# CITY OF ALBUQUERQUE

**RE: Lot 17, Block 4, Unit 19 Volcano Cliffs Subd.  
6531 Vista Del Prado NW  
Request for Permanent C.O. - Accepted  
Engineers Stamp Date 5/5/16 (D10D003T17)  
Certification Dated: 12/21/16**

PREPARED BY STEVEN J. METRO, PE AND PS  
**GRADING & DRAINAGE PLAN**  
**6531 Vista del Prado, NW**  
**LOT 17, BLOCK 4, UNIT 19 VCS**  
Sheet 2 of 2

GRADING & DRAINAGE PLAN
6531 Vista del Prado, NW
LOT 17, BLOCK 4, UNIT 19 VCS
Sheet 2 of 2

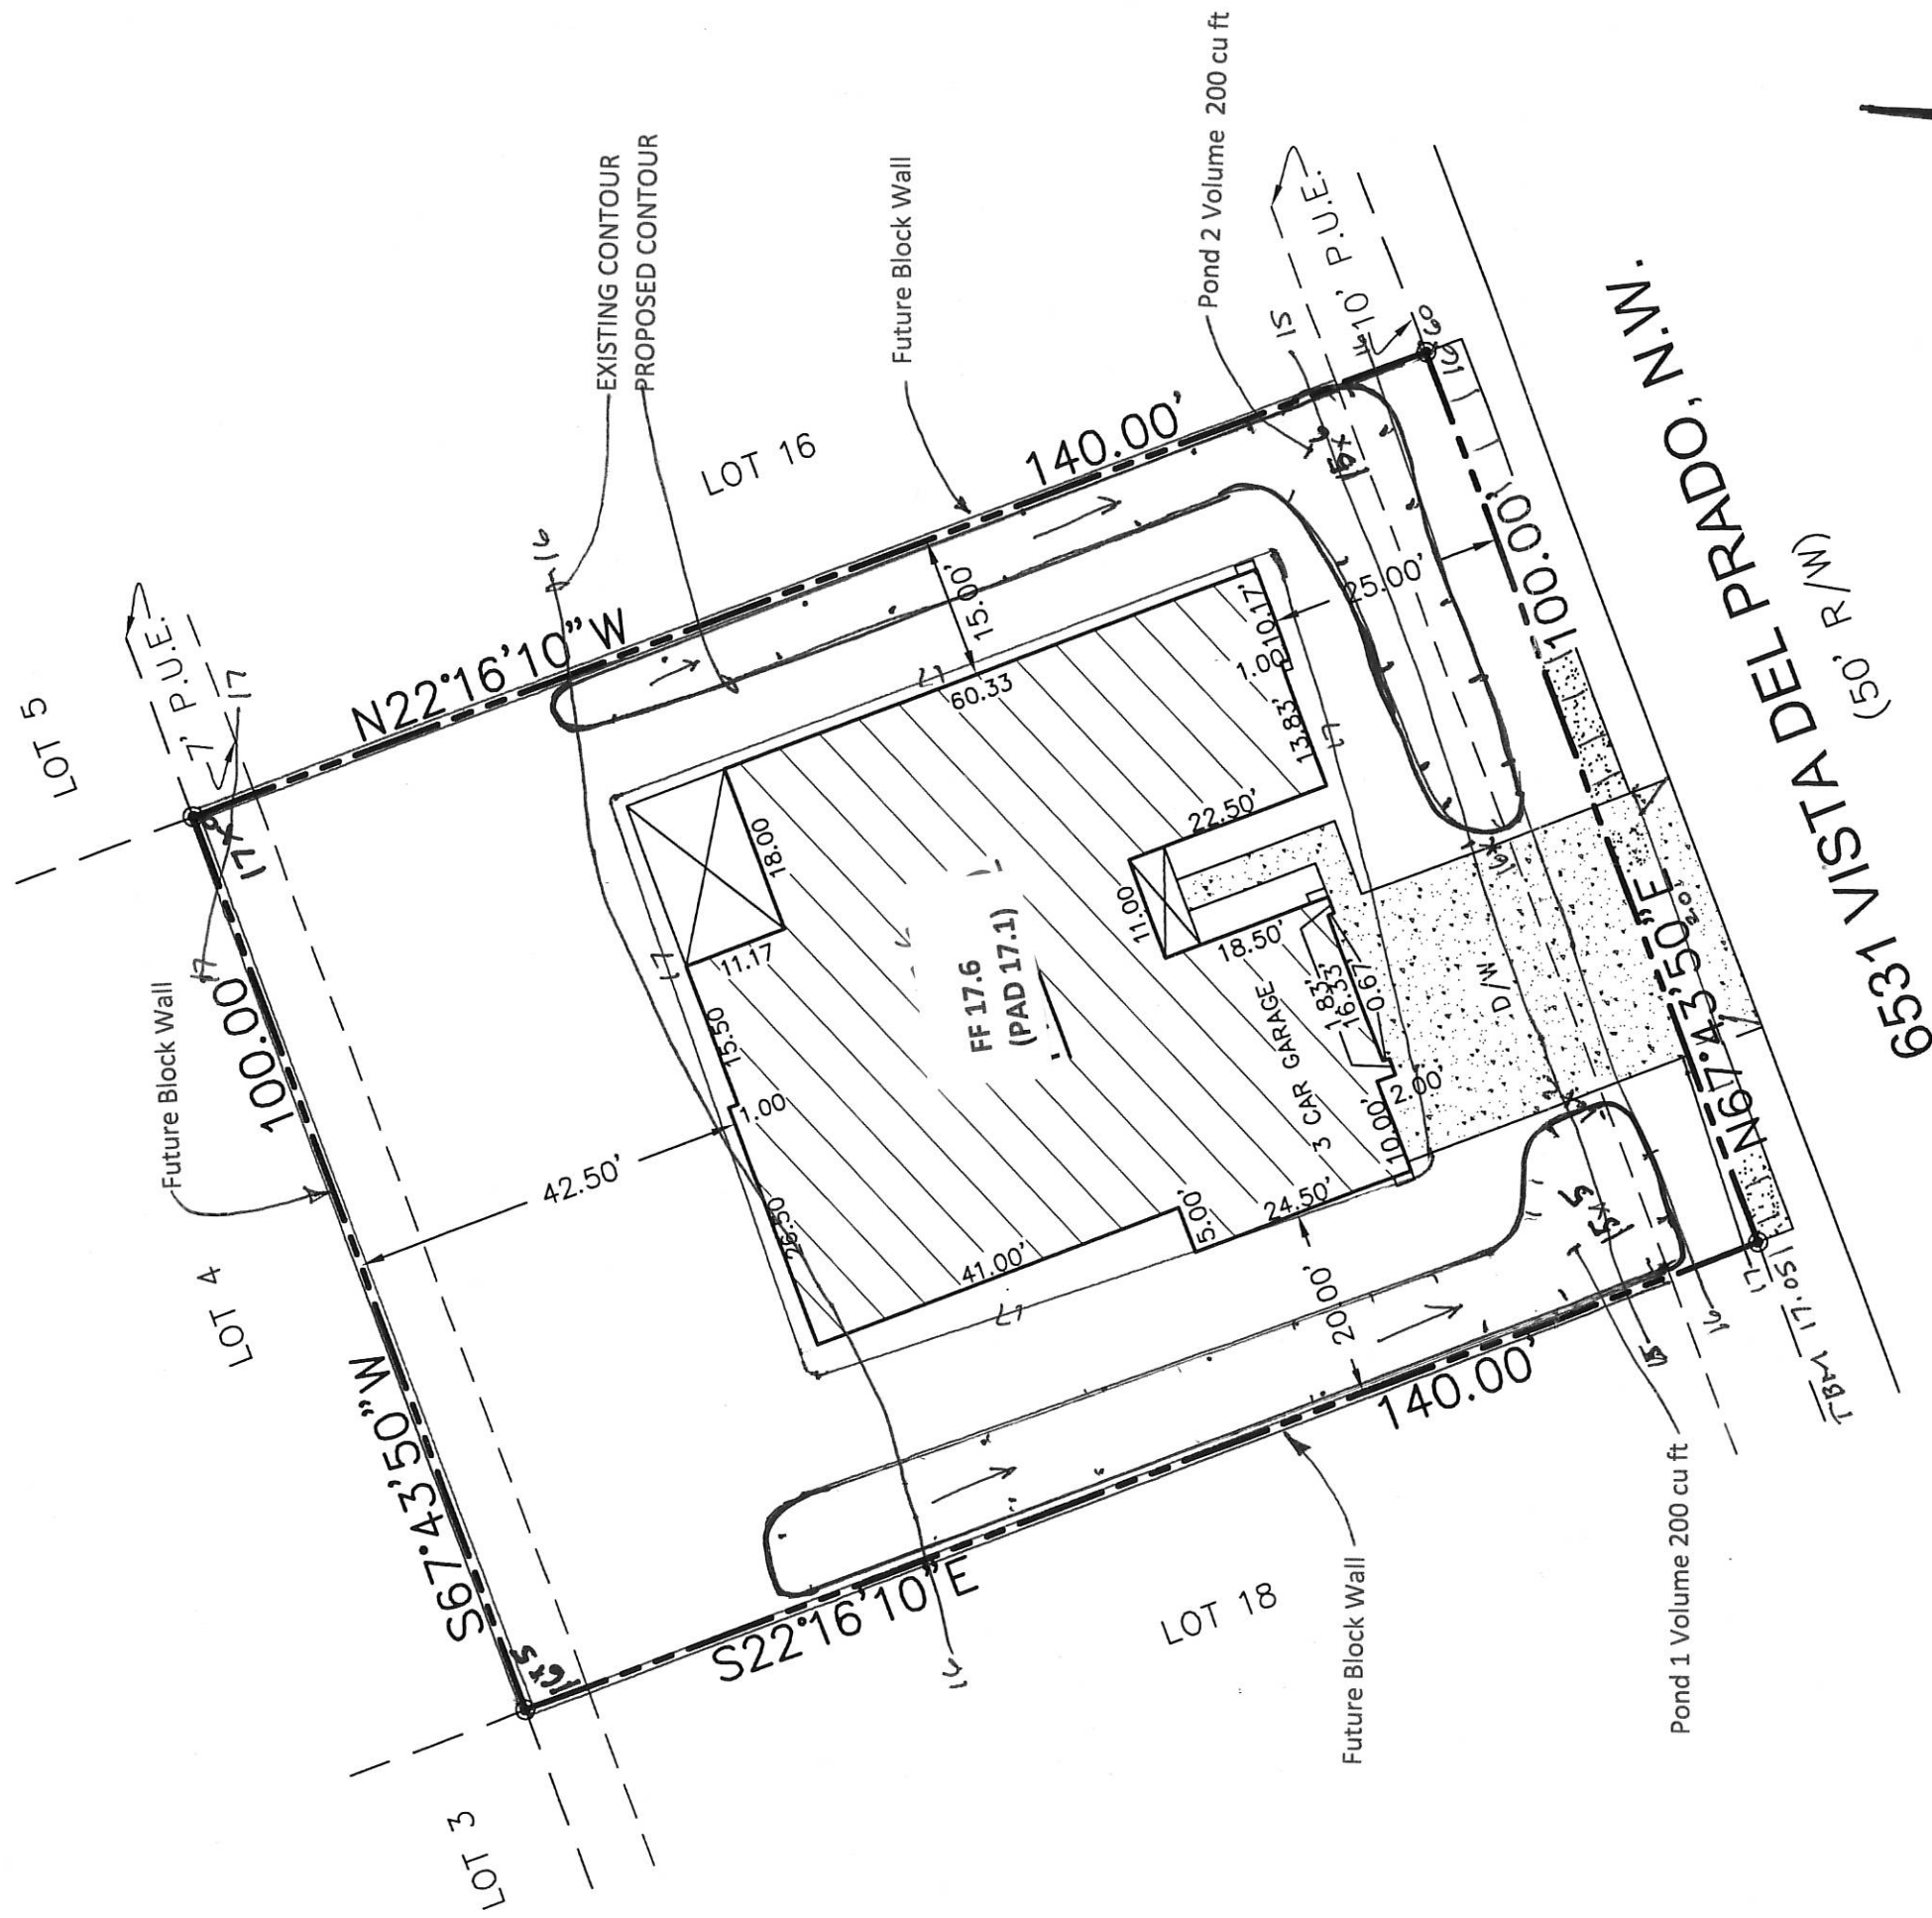
- The ponds are present however they are not landscaped. During the landscaping phase the volume (size), shape and integrity of the ponds must be maintained per the City of Albuquerque drainage ordinance.
- The ponds must be stabilized with landscaping within 90 days from the date of this letter.
